The Homestead
Chapel Lane
Bodicote
Banbury
OX15 4DB

21/10/2019

We are writing in connection with the planning application no 19/02001/F. We would like to provide our comments, please see points 1 and 2. We are also providing objections, please see points 3 and 4.

**SITE PLAN**  
(Scale 1:200)

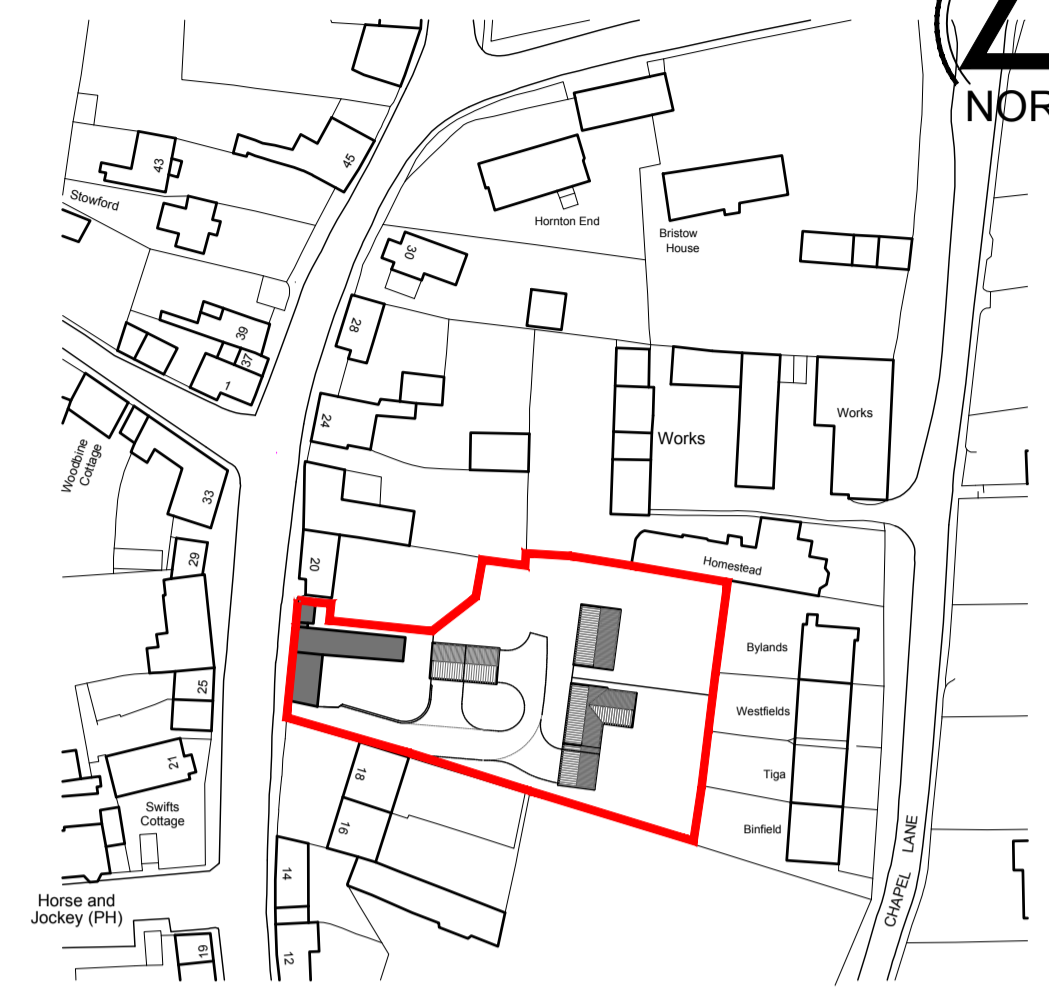
3. The most distressing point and the one that would have the greatest impact on us, concerns the positioning of the proposed development nearest to our property. Based on the current proposals, there is only 3.75 metre gap from our garden wall to the proposed development. With a building 9.25 metres high this would greatly affect the light to the westward facing windows of our living room at the rear of the house and we believe this would contravene our common law right to light.

4. The same proposed development would also completely over shadowed our patio area based on the planned proximity and height.
